KIRKLEES METROPOLITAN COUNCIL INVESTMENT & REGENERATION SERVICE

DELEGATED DECISION TO DETERMINE PLANNING APPLICATIONS TO CARRY OUT DEVELOPMENT WITHOUT COMPLIANCE WITH PLANNING CONDITIONS PREVIOUSLY ATTACHED

Reference No:	2026/70/91355/W
Site Address:	6, Moor Park, Bradshaw Road, Honley, Holmfirth, HD9 6RJ
Description:	Variation of conditions 2 (plans) and 3 (materials) on previous permission 2026/90330 for erection of single storey rear extension and sun room with attached store, including decking area and associated works
Recommending Officer:	Joshua Merriman

Officer Report – 2026/91355

Client Michelle Falkingham-Bailey	
Project Proposed Extension to Dwelling 6 Moor Park, Bradshaw Road, Honley HD9 6RJ	
Drawing Proposed Elevations	
Number 4455-03-05a	Date 11/2025 Scale @ A1 As Marked

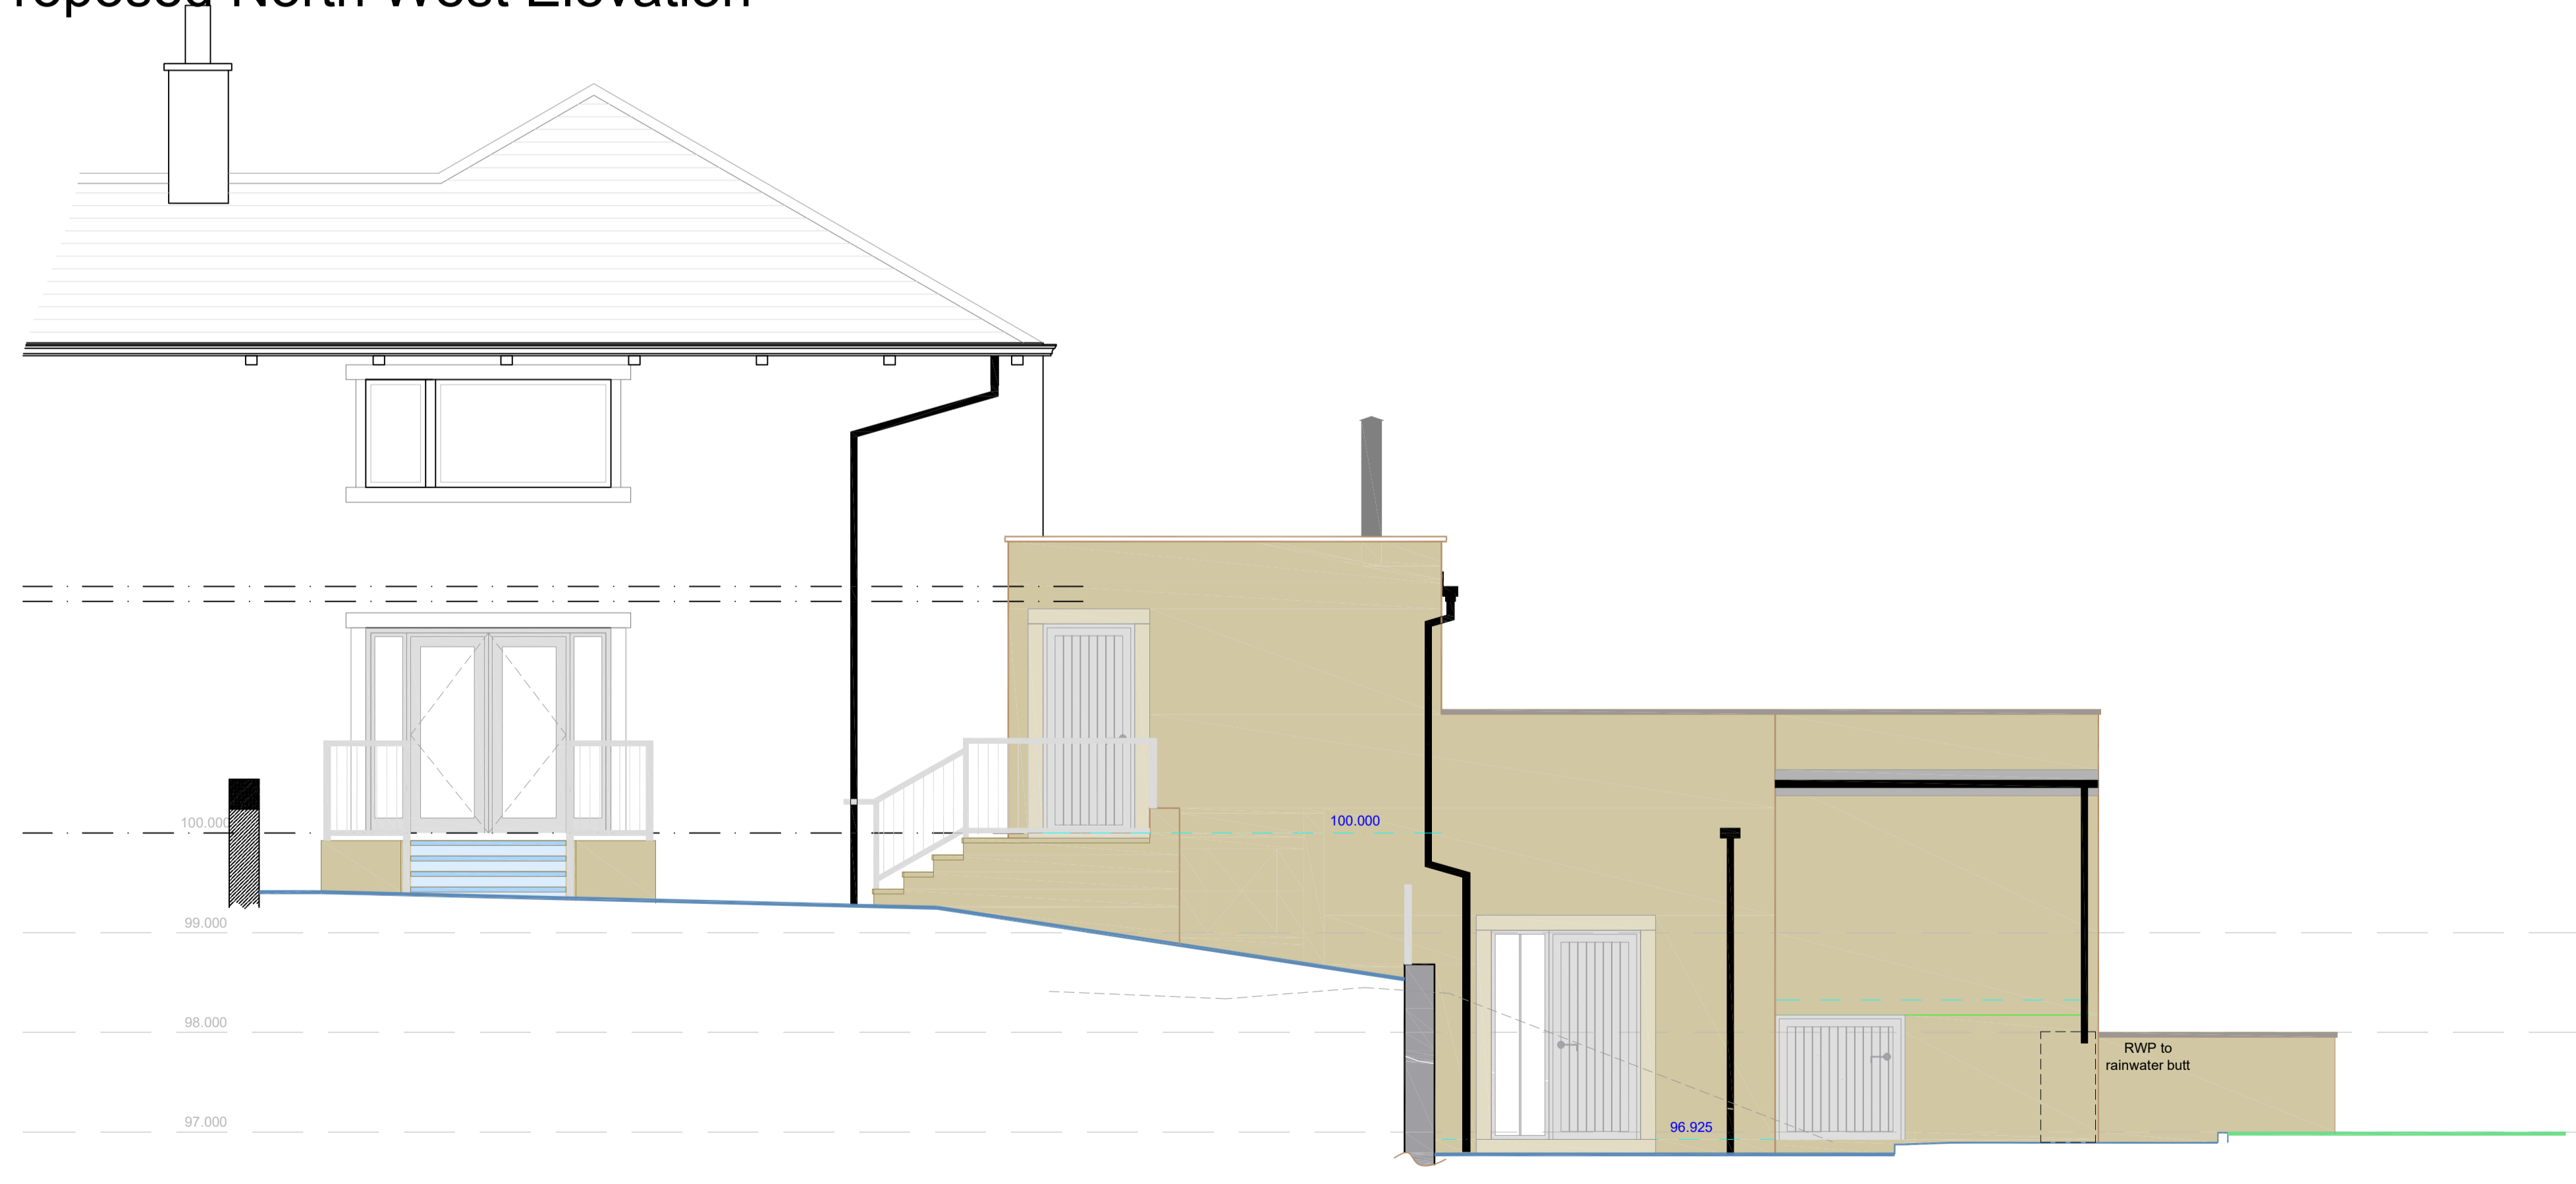
- The use of a flat roof to the higher-level rear extension rather than a pitched roof.
- The use of flamed flat roof lights to the higher-level rear extension rather than velux type roof lights.

The use of a flat roof and framed flat roof lights to the rear extension rather than a pitched roof and Velux roof lights is not considered to significantly impact the visual amenity of the development as the extension is located to the rear of the property, and will use a flat roof to the lower-level extension as approved. Furthermore, given the land to the rear of the property is largely an open expanse, the extension will not be highly visible in the local area, having little impact on the character of the area.

3. The external walls used in the construction of the development shall in all respects match those used in the construction of the existing building.

Client Michelle Falkingham-Bailey	
Project Proposed Extension to Dwelling 6 Moor Park, Bradshaw Road, Honley HD9 6RJ	
Drawing Proposed Floor Plans	
Number	Date 11/2025
4455-03-04a	As Marked

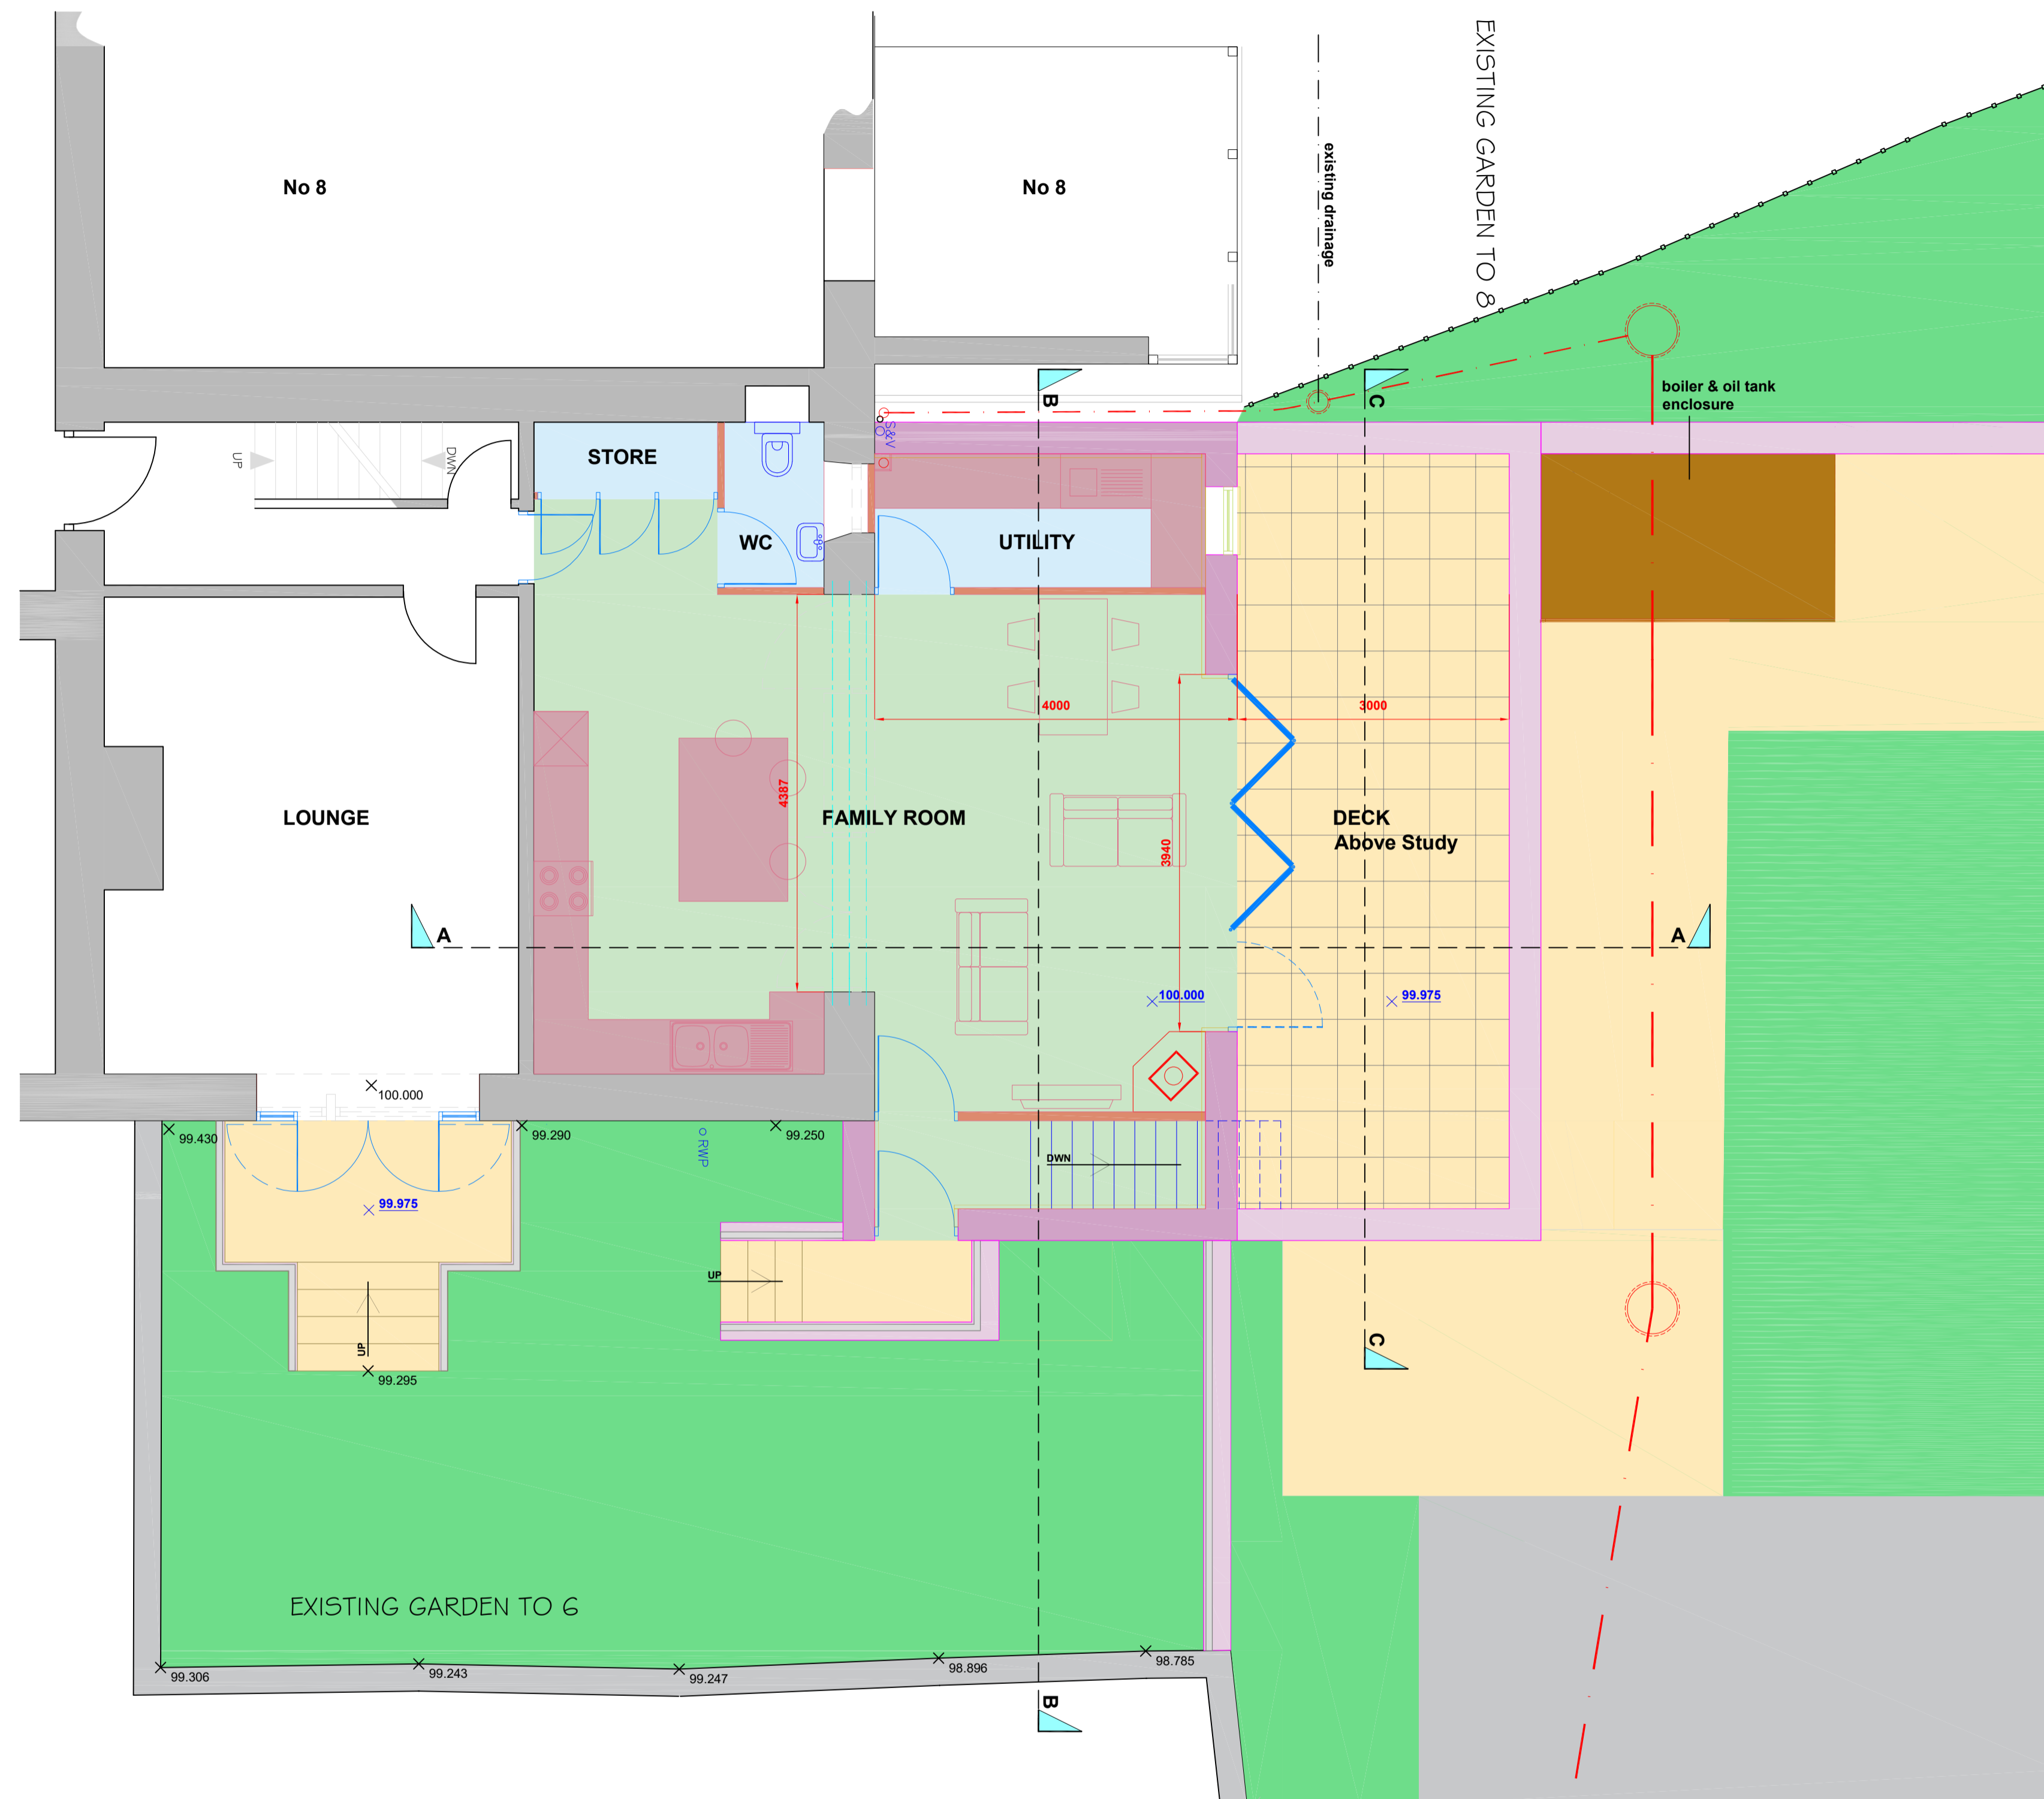
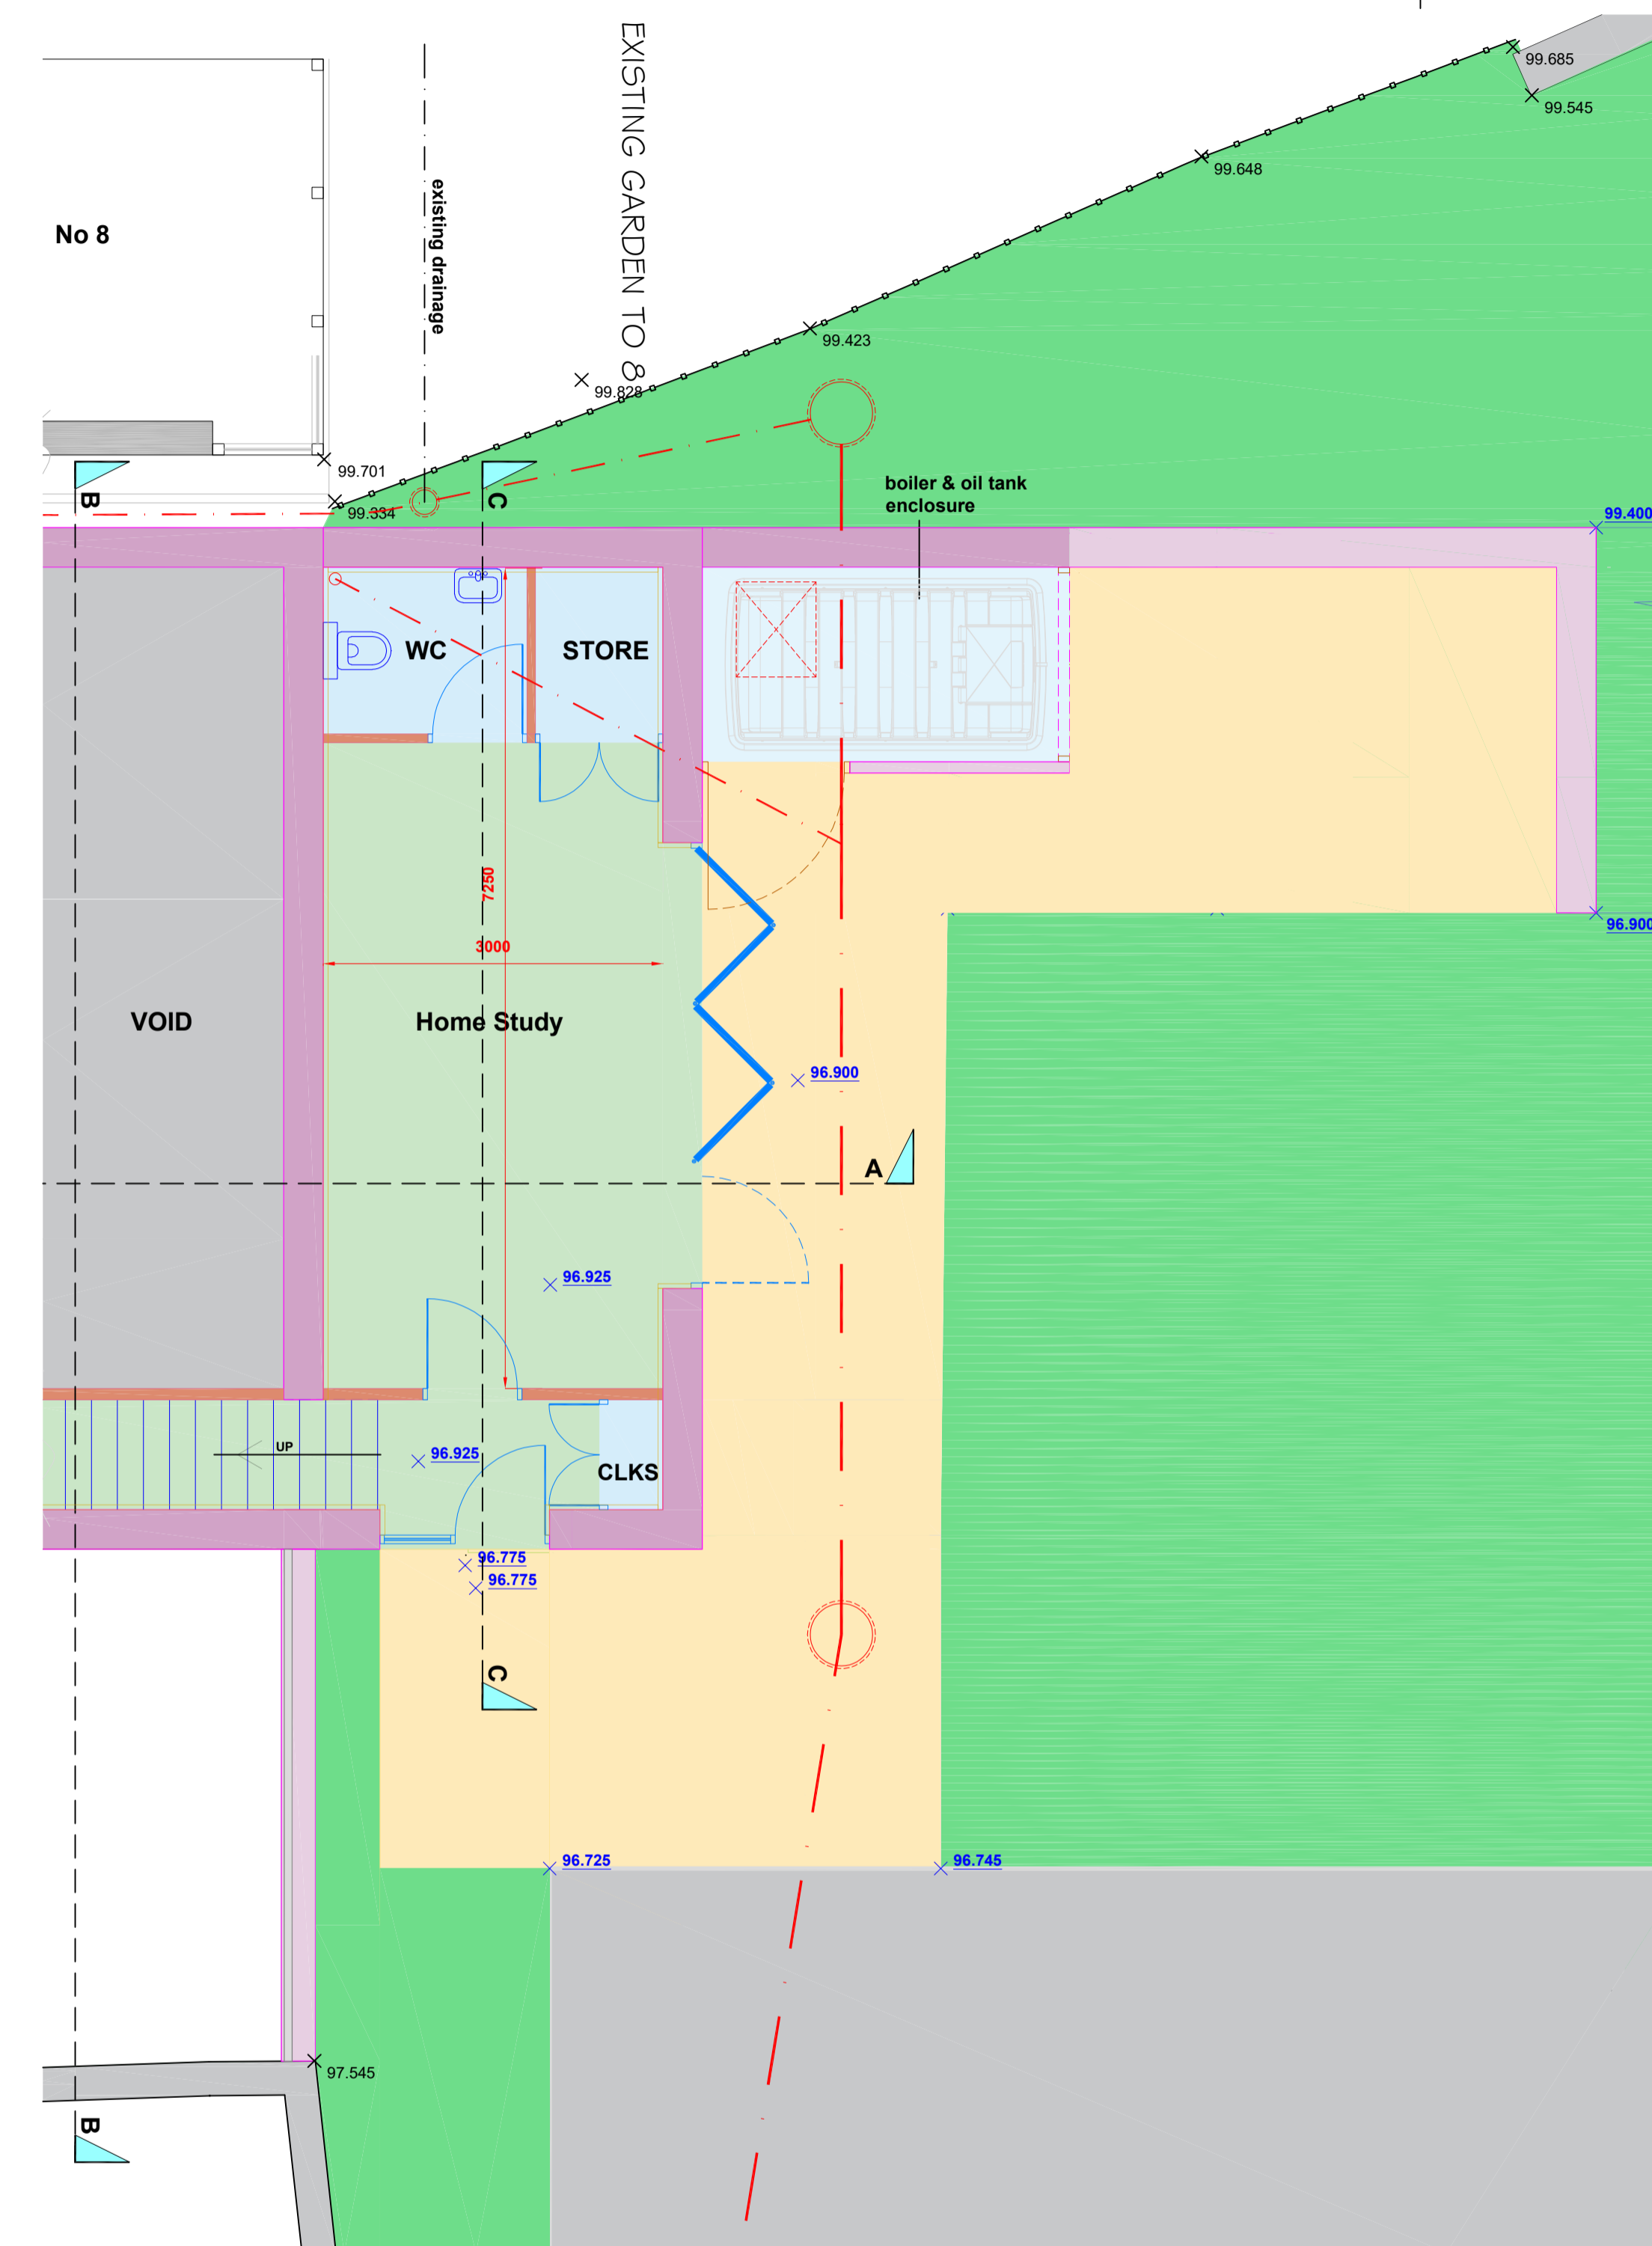
As the roof lights proposed will not facilitate any extra overlooking onto neighbouring properties, and the flat roof will cause a reduction in the scale of the development, it is considered that there will be no significant impact upon neighbouring properties regarding overshadowing, overbearing, light, outlook, privacy, and overlooking.
